INDIVIDUAL PLANNING OBJECTION

Waterloo South SSDA — SSD-93222706

8/237 Cope Street, Waterloo NSW 2017 — PT 23 — SP79210

Sawtooth Warehouse Conversion — 237 Cope Street | Individual Objection Template |

Drawing Name
Blocks 2 & 3
 Proposed Envelope - Plan

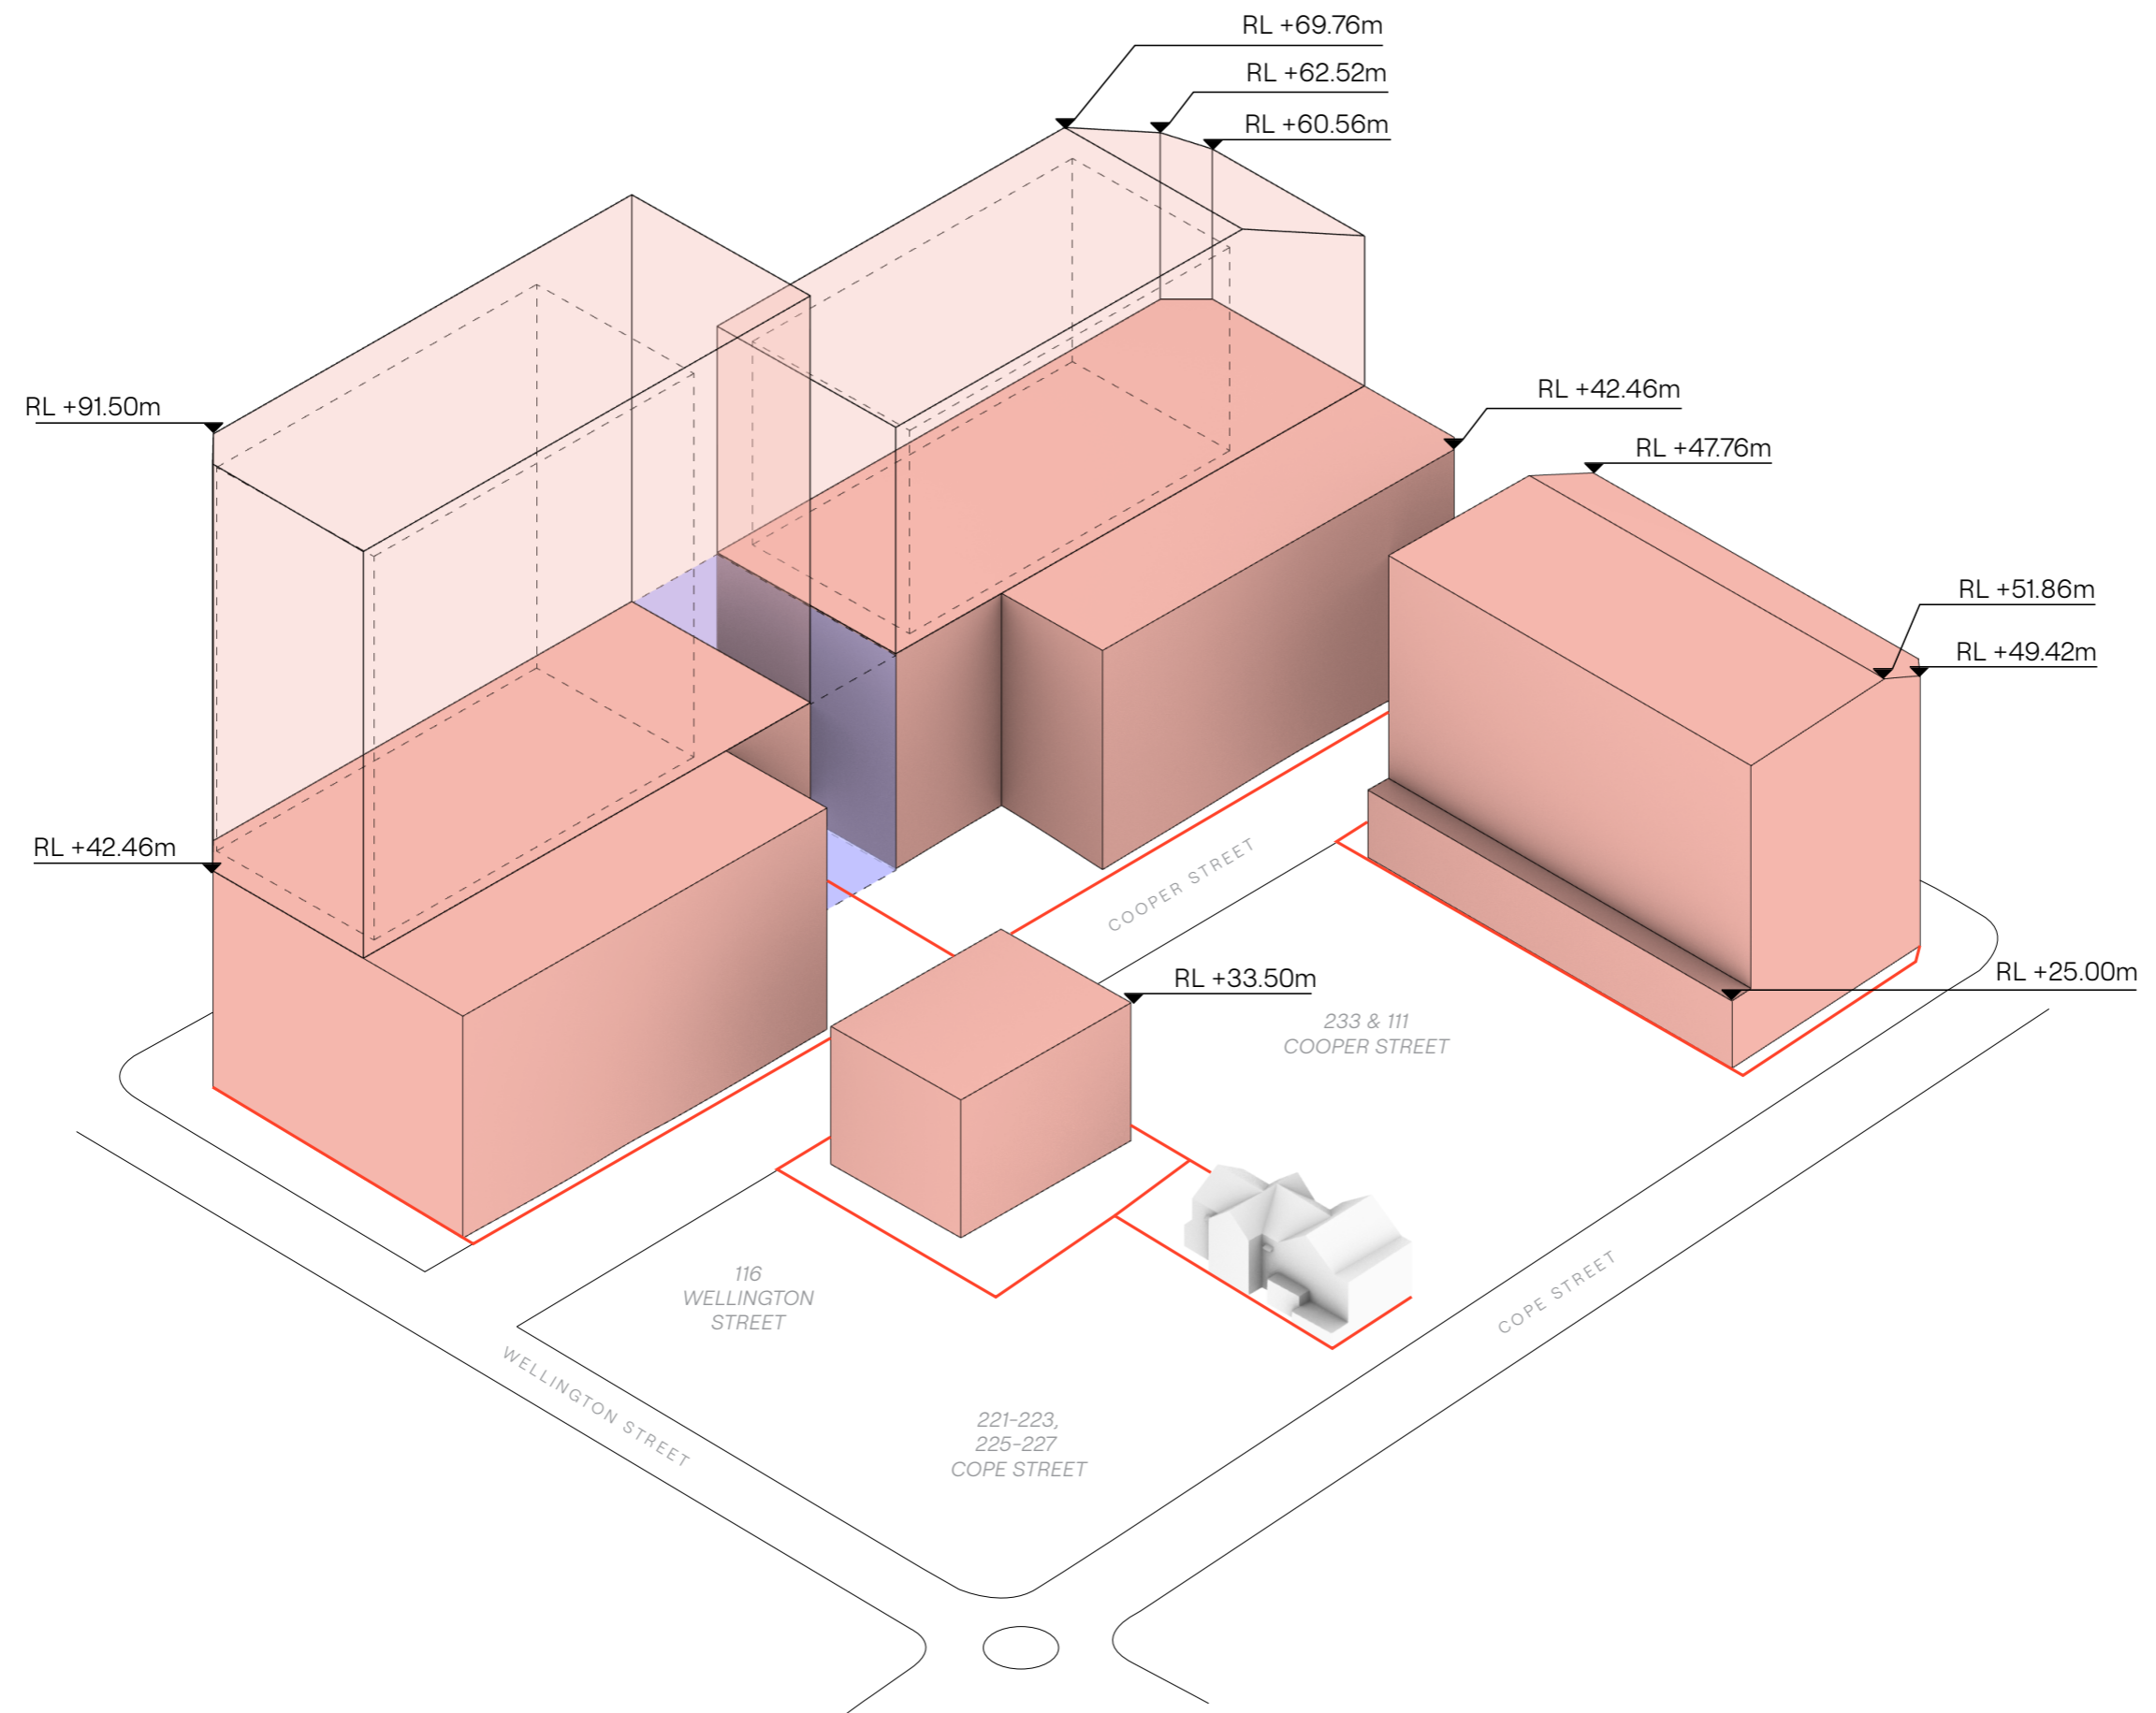
237 Cope Street is a 1930s industrial warehouse conversion. My unit shares the building's distinctive internal typology: sawtooth clerestory glazing and apex skylights that face east and south toward the proposed development site. The proposed Lot 2D (Cope Street face, 9 storeys, RL +51.86m) will block morning eastern solar access to these skylights. The proposed Lot 3B (John Street face, RL +69.76m, 15 storeys) will block the southern sky dome from the double-height glazed void walls shared by Units 3–10. This solar and architectural impact is unique to our building — no other properties in SP79210 share this typology. No solar access analysis has been conducted for 237 Cope Street.

- **Loss of solar access:** The proposed Lot 2D (9 storeys, RL +51.86m, 3m setback from Cope Street) is positioned directly opposite my building. The EIS Urban Design Report confirms Cope Street receives between 0 and 1.75 hours of winter solstice sunlight under the proposed envelopes. No solar access analysis has been conducted for privately owned properties on the western side of Cope Street in breach of SEAR 7.
- **237 Cope Street — architectural solar dependency:** The sawtooth clerestory glazing and apex skylights of my unit are entirely dependent on unobstructed eastern morning solar access (threatened by Lot 2D) and southern sky access (threatened by Lot 3B on John Street, RL +69.76m). Blocking these specific light sources

- Require supplementary solar access analysis modelling overshadowing of my property at hourly intervals between 9am and 3pm as required by SEAR 7
- Require a supplementary Visual Impact Assessment with viewpoints from within my property and other privately owned properties on Cope Street
- Require the proponent to provide the comparative analysis of the two-storey height protection removal required by SARP Study Requirement Item 3
- Require a Construction Environmental Management Plan addressing impacts on privately owned properties on Cope Street prior to demolition or excavation
- Appoint the Independent Planning Commission as consent authority
